Mallard Pass_ISH2_12 July_PT4

FULL TRANSCRIPT (with timecode)

Plate 7: Typical PV Array

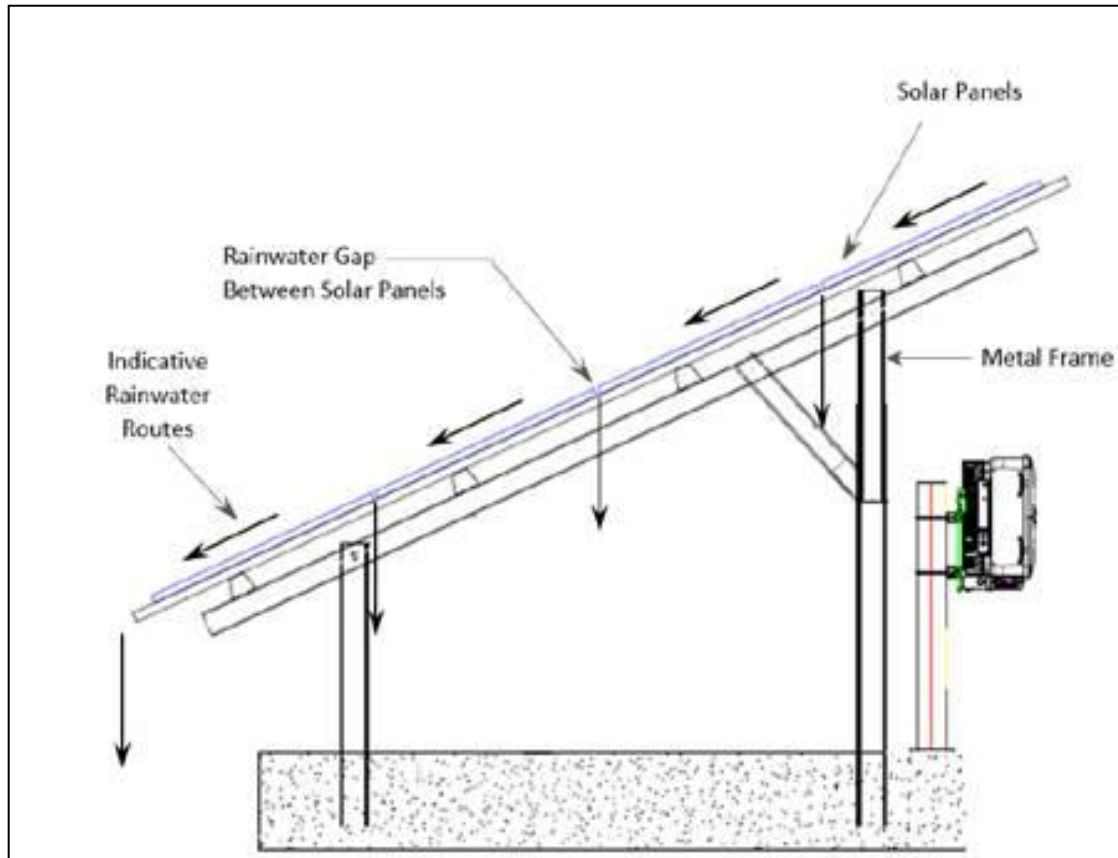
some questions do remain so in terms of the potential for flood risk due to the possible concentration of runoff from the from the panels has been raised as a concern. And Grapefruits Parish Council has written representation. They've produced some calculations of their own in terms of.

The fact that they believe 6.37% of the area underneath the panels will receive 100% of the rain falls on those panels. And I'm not sure if the applicant responded to that point directly. The deadline three submission.

Thank you, Mr. Fox. Mr. Evans, on behalf of the applicant. Don't think that point was specifically covered in the written representations of the last deadline. I would note that the authors have regular brain water gaps. It's not just a shooting of surface water. As precipitation falls upon it onto a concentrated drip line. There are several drip lines and that would allow rainwater to fall onto the subsoil underneath. But again, we can provide some clarity guess and the next round of written reps.
